Planning  
Observation

ABP Ref. 313322

Priorsland SHD,  
Townlands of  
Carrickmines Great  
and Brennanstown,  
Dublin 18.

For Quintain  
Developments Ireland  
Limited

**SECTION A-A
 SECTION CENTRAL ON PROPOSED BRIDGE - PUNCH PROPOSALS**
 SCALE 1:50

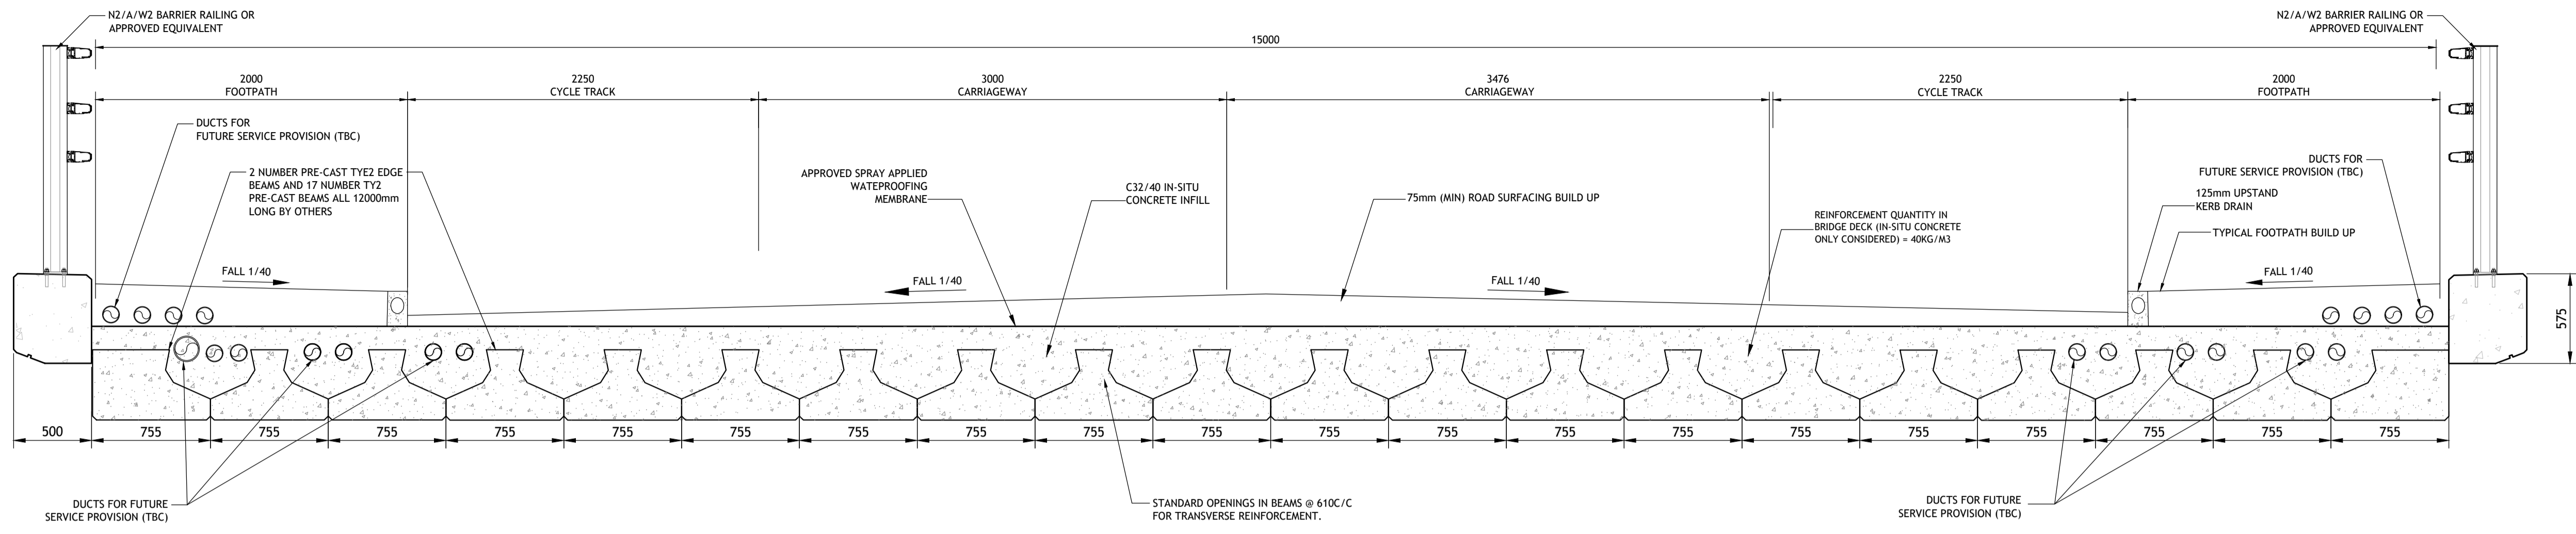
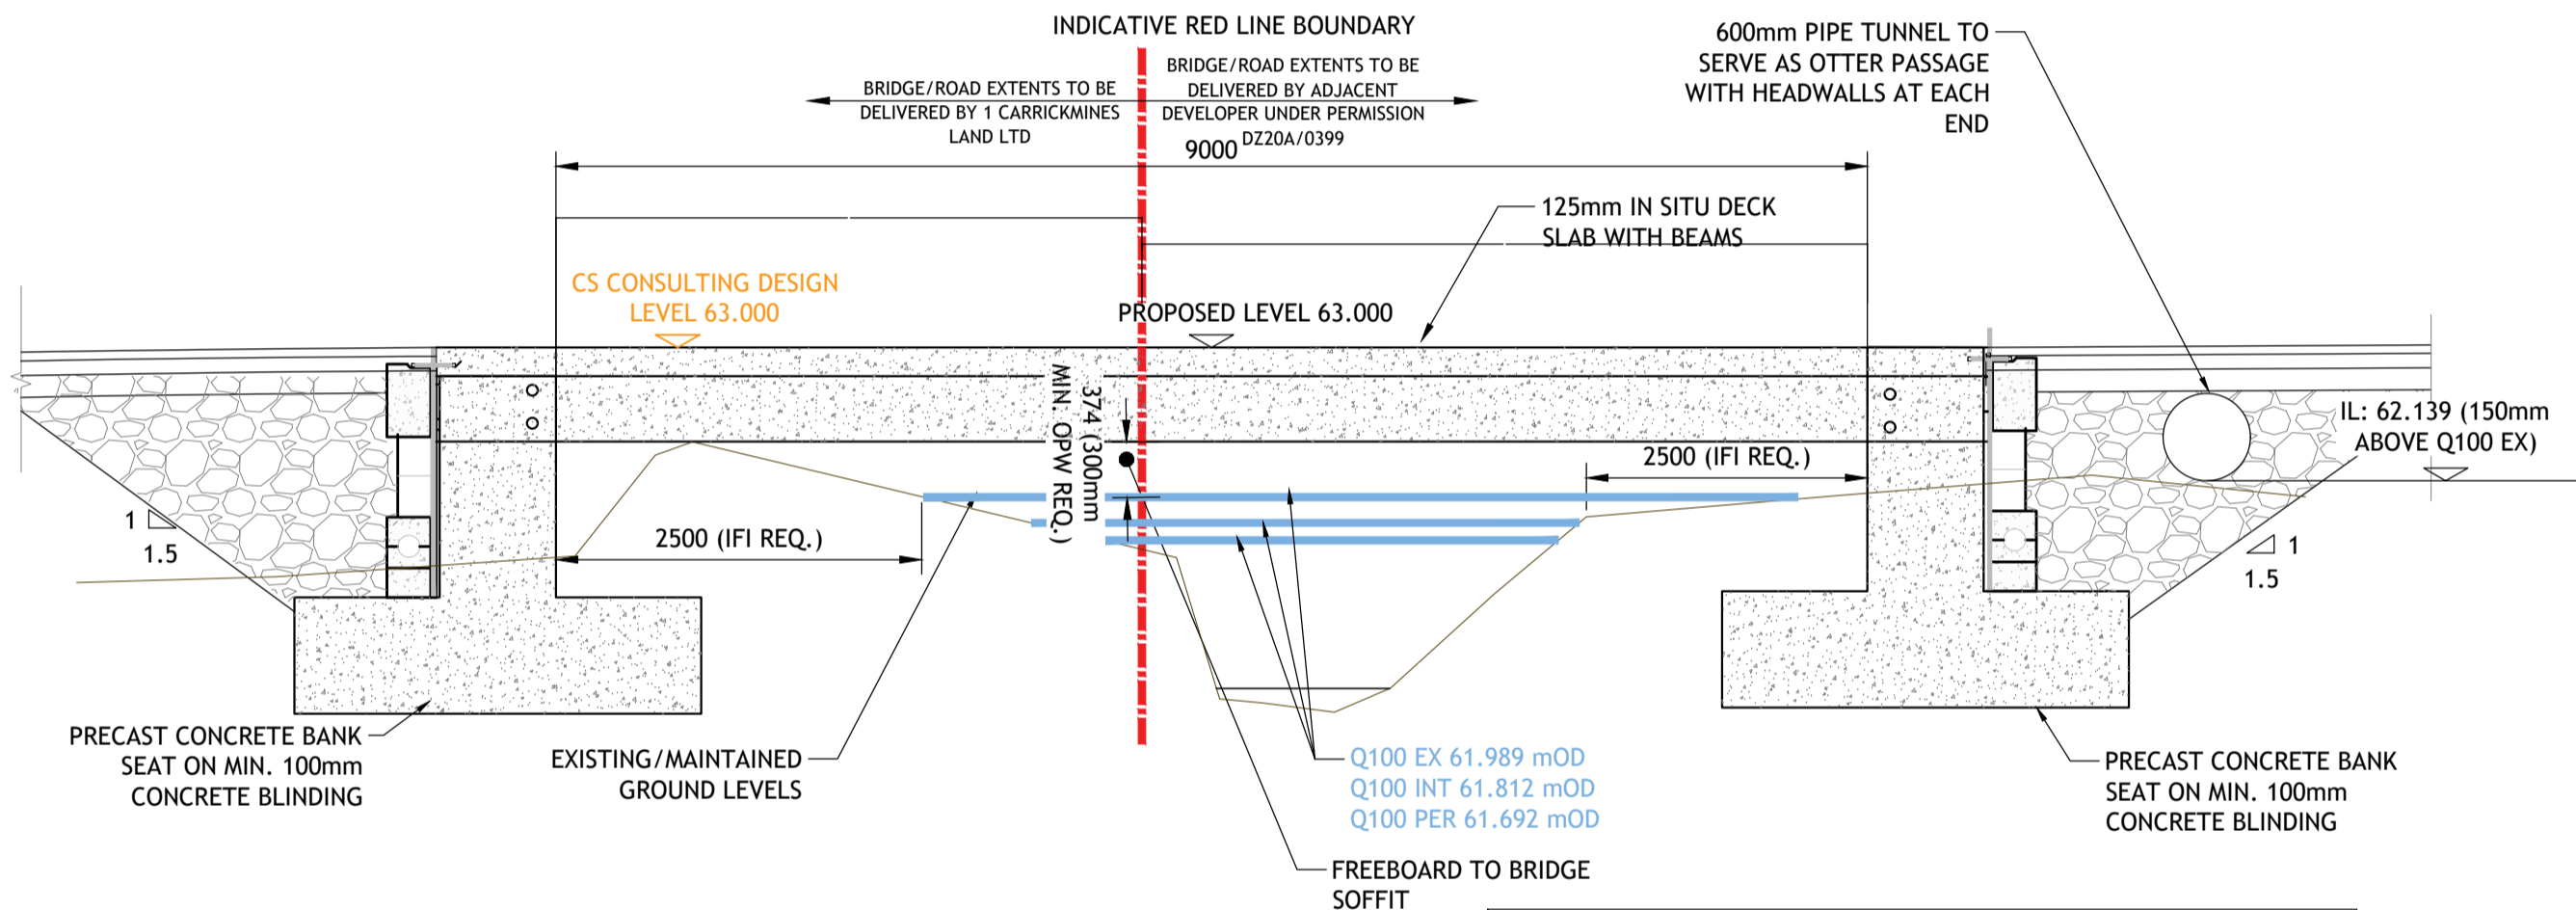
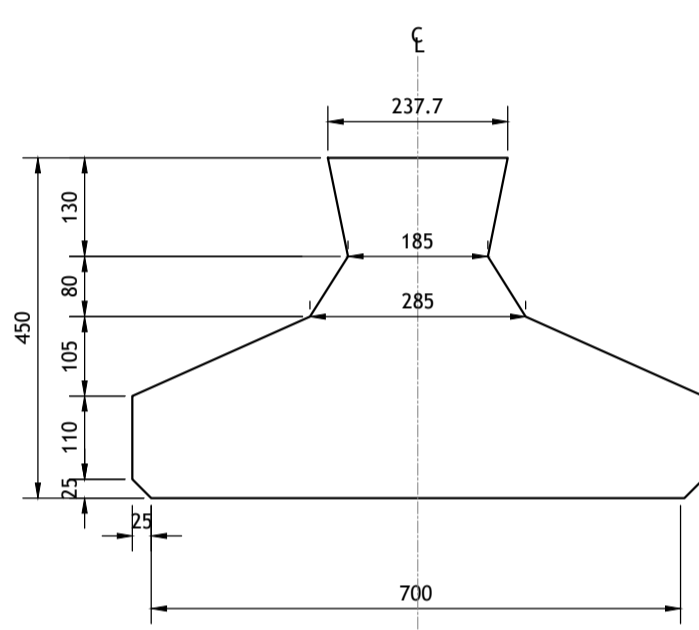
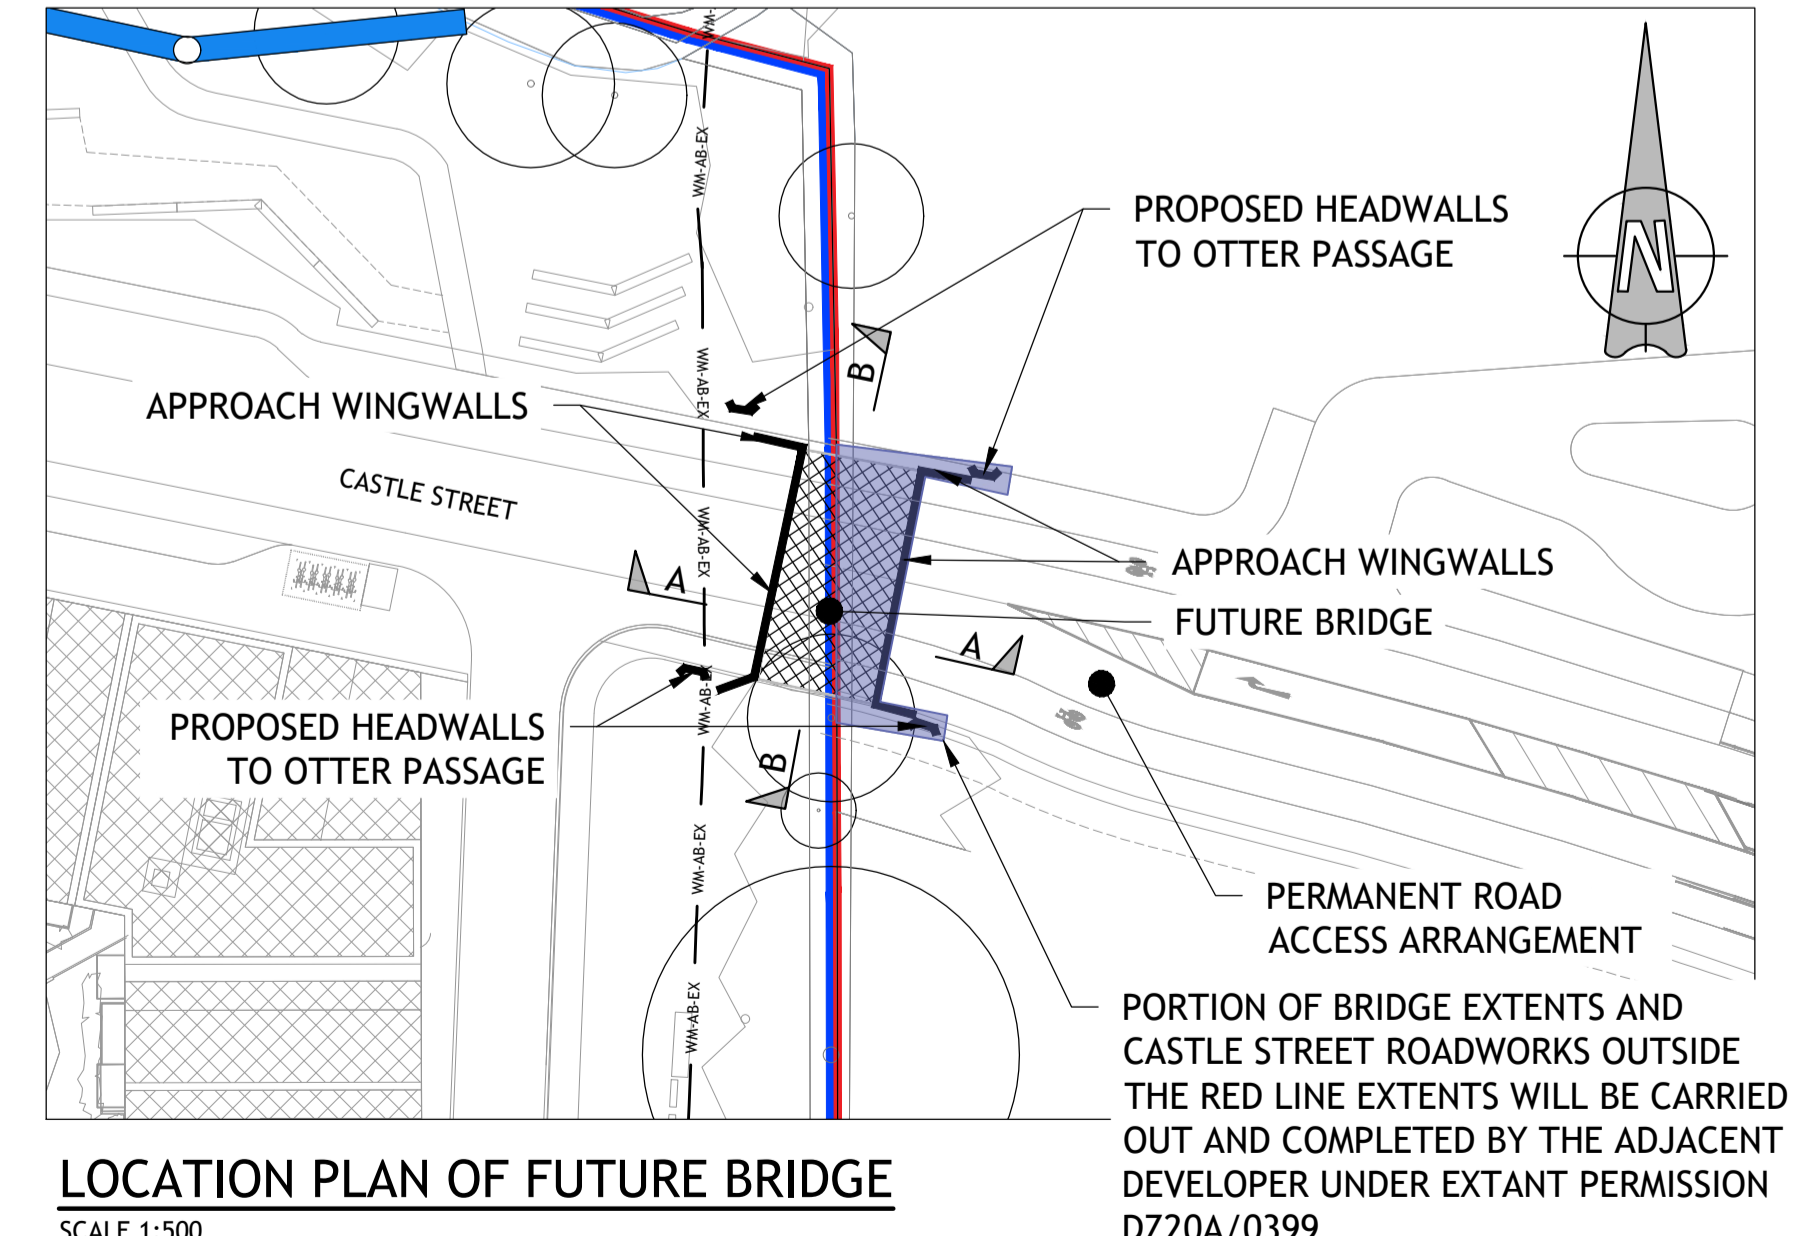
- The Applicant also does not mention the exact location of the existing water main as it runs up past the Ticknick Stream. It appears that the alignment is diagrammatically shown on the engineering drawings and passes in close proximity to the suggested bridge crossing over the Ticknick River. If the main clashes with the bridge, you cannot build the bridge until the main is diverted so you could point out their development is premature as the diversion route needs to be agreed at least before a grant of permission. – our land, no consent

- The Applicant does not seem to have carried out any flood risk assessment or even commented on the bridging detail on the Ticknick Stream and if that has any effect on the upstream/downstream flows during a storm event.
